Submission to An Coimisiún Pleanála

Re: Proposed Lissinagroagh Wind Farm, Co. Leitrim

Case Reference: PAX12.324290

From: Mihaela Davidescu and James McMorrow

Figure 13-1: Full 20 km extent of the Study Area

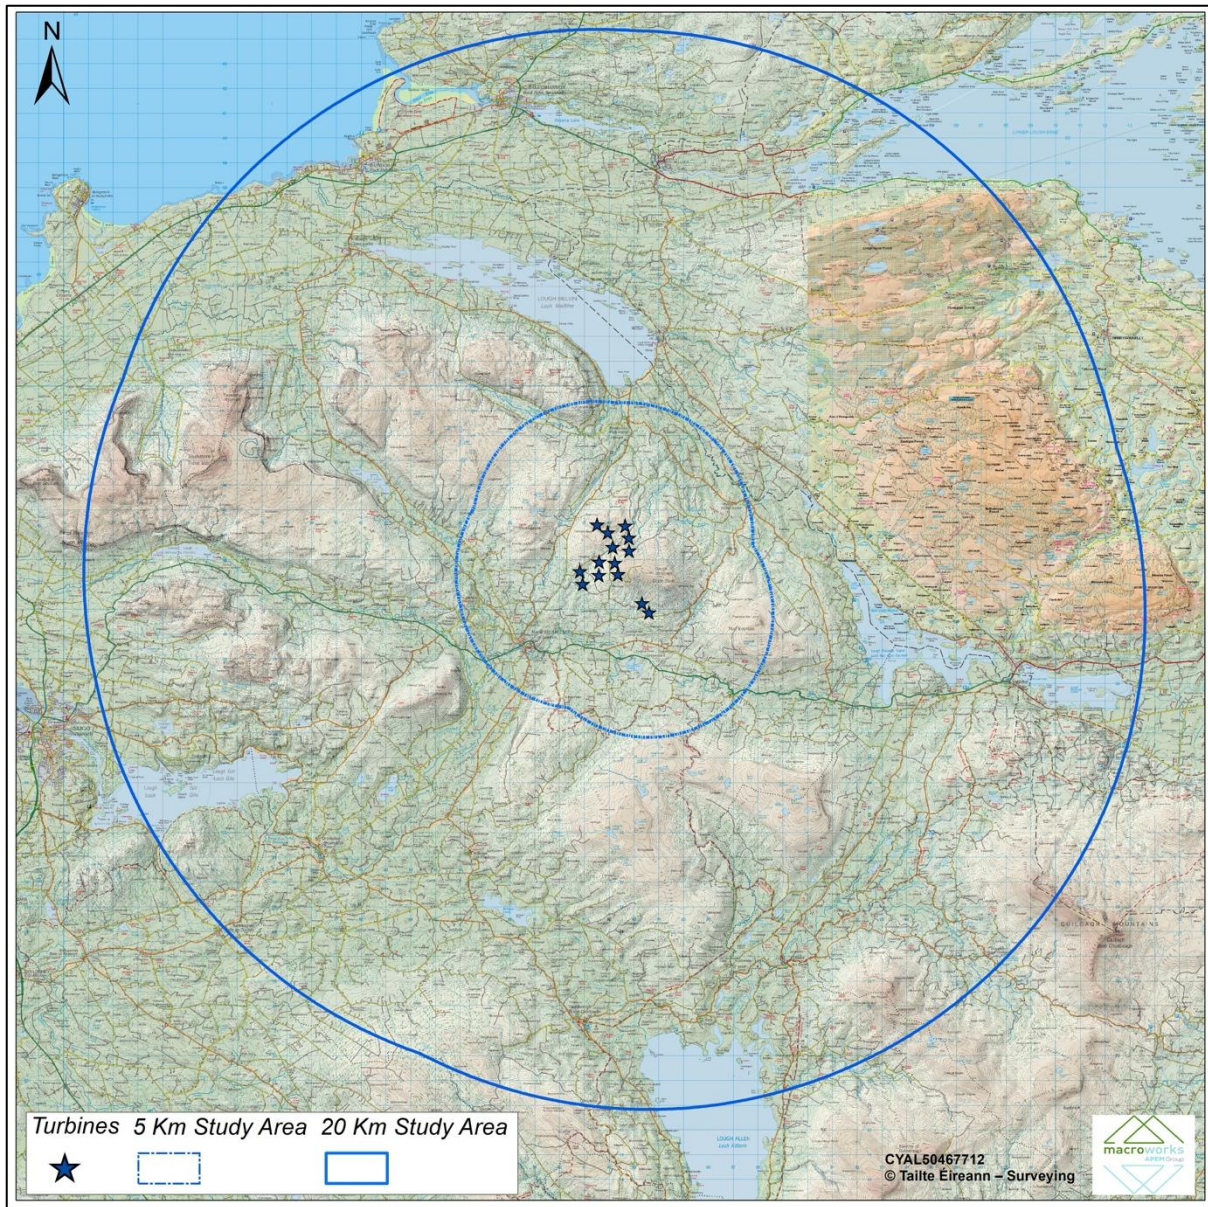
The methodology in Chapter 13 of the EIAR provides for a 25-km study radius "where landscape features of national and international importance exist". However, a 20-km study area was adopted on the stated basis that "there are no landscape features of national or international importance between 20–25 km". Chapter 14 likewise states that "There are no UNESCO World Heritage sites within the 30km of the proposed wind farm. Additionally, there are no sites included on the tentative list located within 30km."

These statements cannot be reconciled with the **Passage Tomb Landscape of County Sligo**, which was submitted to UNESCO for Ireland's World Heritage Tentative List in January 2023. (Please refer to <https://www.worldheritageireland.ie/tentative-list/the-passage-tomb-landscape/> and <https://whc.unesco.org/en/tentativelists/6635/>)

Using the turbine coordinates provided in Table 2-1 of the EIAR, the **Carrowmore passage tomb complex** lies approximately 27–28 km from the nearest proposed turbine and therefore falls within the 30-km radius referred to in Chapter 14.

The great cairn on Carns Hill, overlooking Lough Gill, is less than 23 km from the nearest turbine and therefore lies within the very 20–25 km distance band where Chapter 13 claims that there are no landscape features of national or international importance.

These Neolithic monuments were deliberately located to maintain extensive intervisibility across the surrounding landscape, and that wider landscape setting forms an important component of the proposed Outstanding Universal Value of the tentative World Heritage property. The potential effects of turbines with a maximum tip height of 185 metres on that wider landscape setting have not been assessed.

For the reasons set out above, we respectfully request that An Coimisiún Pleanála refuse permission for the proposed development or, at a minimum, defer its determination pending the adoption by the Northern and Western Regional Assembly of the onshore renewable energy and landscape strategies required by section 29 of the Planning and Development Act 2024, and require a revised Landscape and Visual Impact Assessment based on a 25-km study area.

Figure 13-9: Excerpt from the current Leitrím County Development Plan 2023-2029 showing landscape designations in relation to the proposed turbines

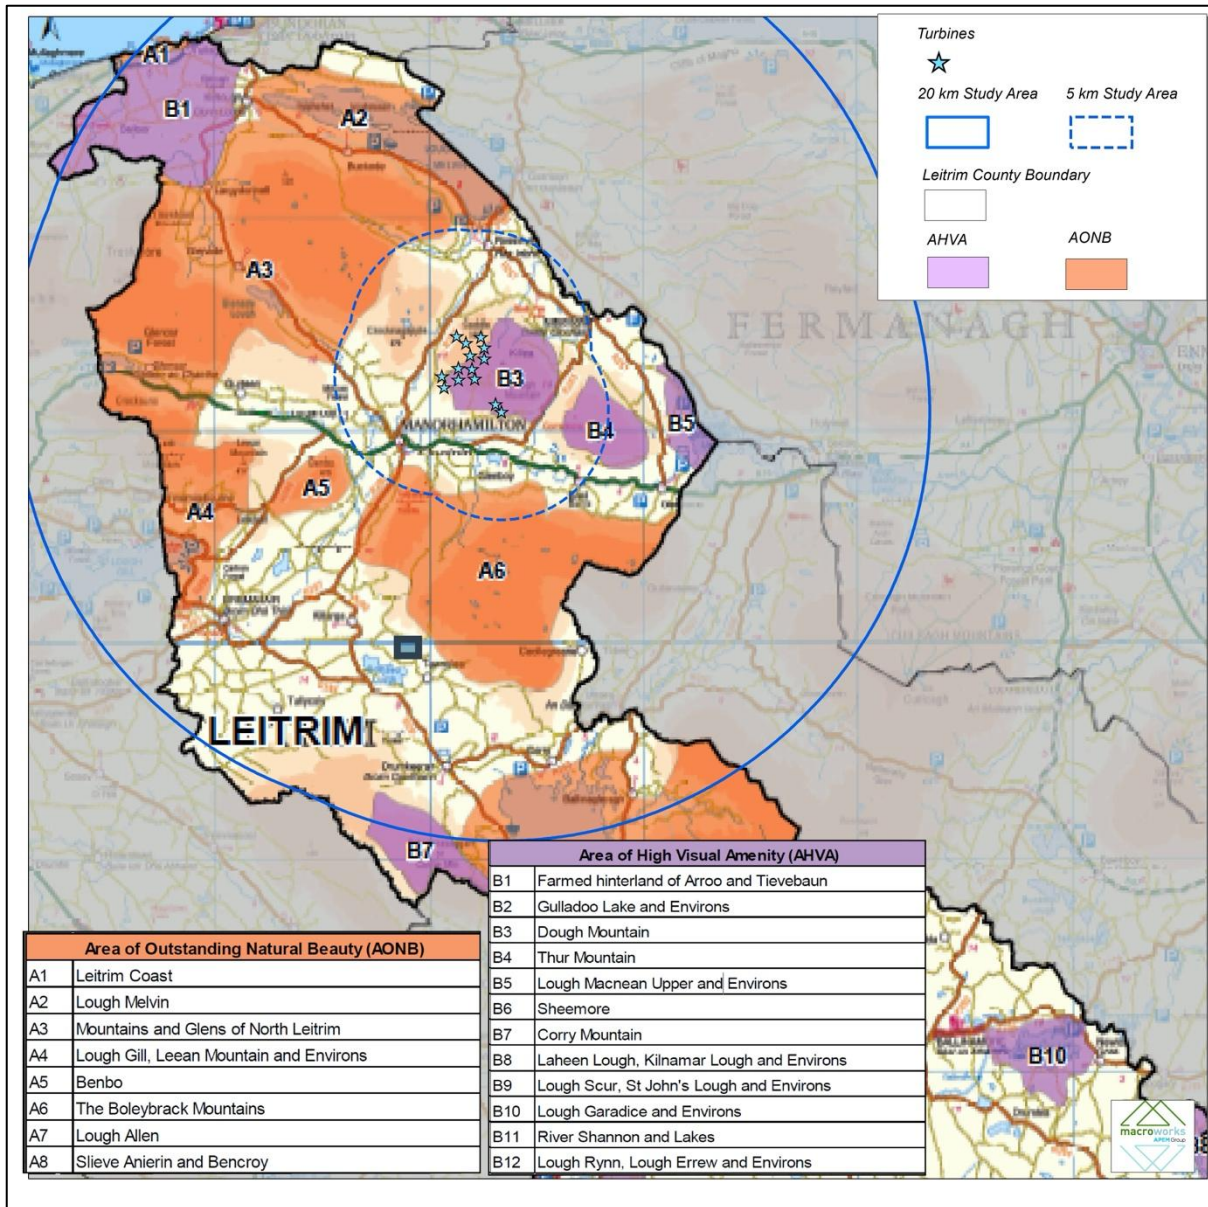
The proposed turbines are sited across the 'B3 – Dough Mountain' Area of High Visual Amenity identified in the Leitrim County Development Plan. The EIAR itself describes the project as "situated partially in and adjacent to" this designated area. The Plan describes this landscape as generally remote and tranquil, characterised by a "smooth rounded mountain skyline... conferring a sense of place on the local area", with panoramic views enjoyed from its elevated locations.

The introduction of turbines up to 185 metres in height would represent a substantial, negative and permanent change to the character of this landscape by placing intrusive, large-scale engineered structures into an upland area specifically recognised for its natural skyline, tranquillity and scenic quality.

Figure 13-10: Bare-ground Zone of Theoretically Visibility (ZTV) Map based on a turbine tip height of 185 m (see Appendix 13-2 for a larger scale map)

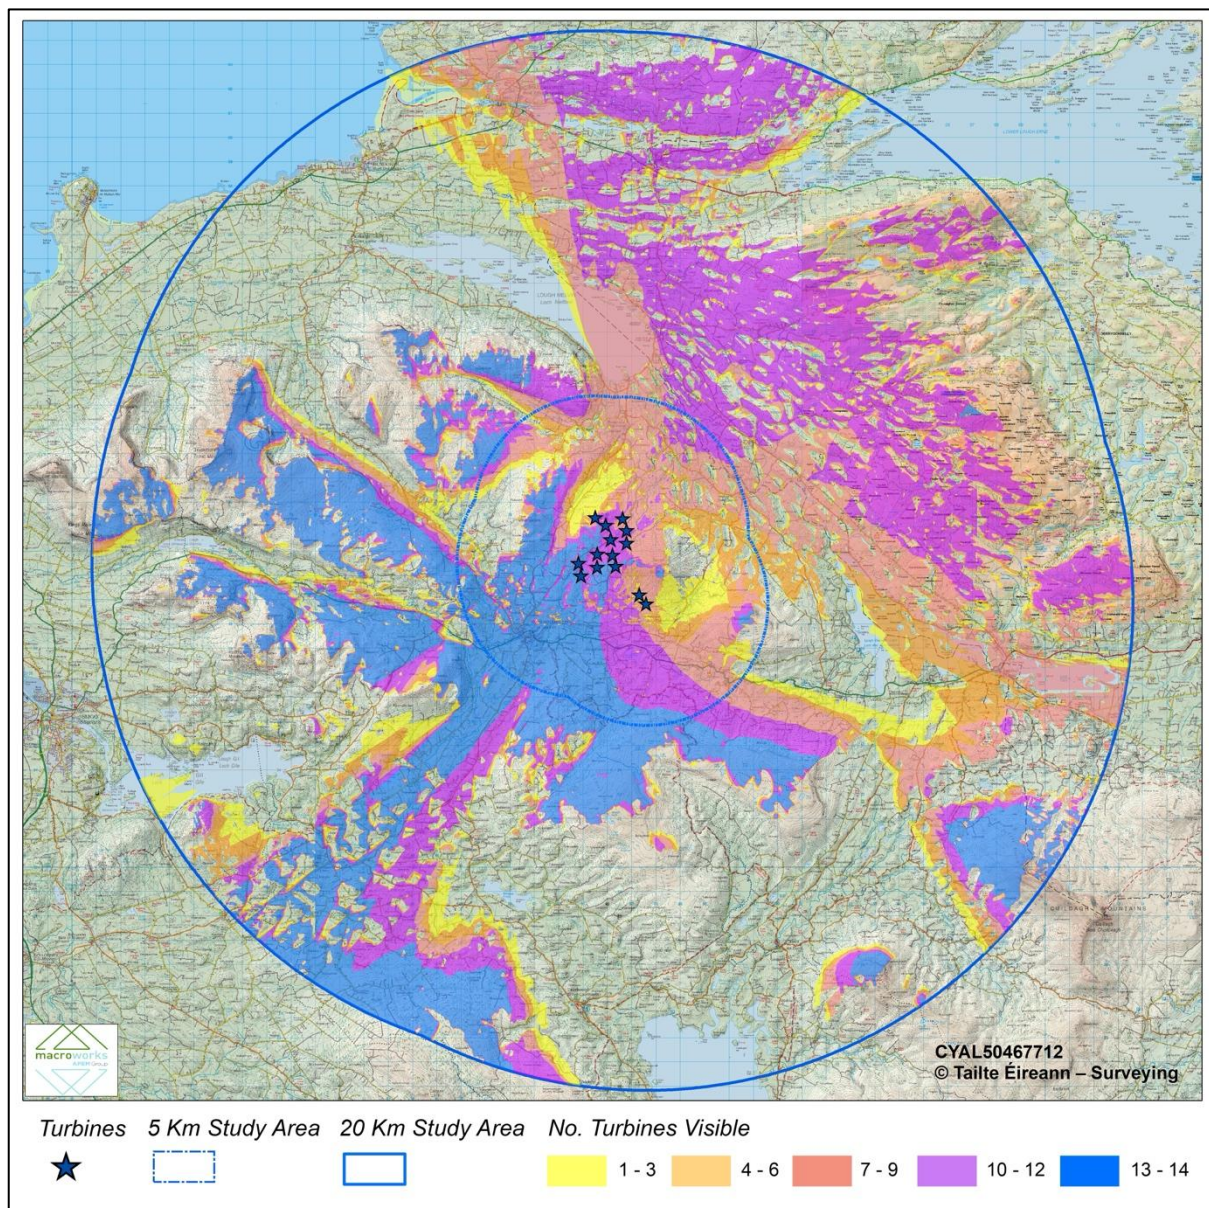
The EIAR's Zone of Theoretical Visibility mapping shows a "star-like pattern" of visibility extending from Manorhamilton along the surrounding valleys. Chapter 13 classifies residual visual effects on the N16 National Primary Route as ranging between Moderate and Slight, with the greatest effects occurring on the sections closest to the site and east of Manorhamilton.

Road users approaching the application site from either direction on the N16, together with those travelling on the R280, R282, R283 and R286, would experience repeated and sequential views of the turbine array. These views would include designated Scenic View V16 and the Area of Outstanding Natural Beauty at O'Donnell's Rock, approximately 4 km south of the site.
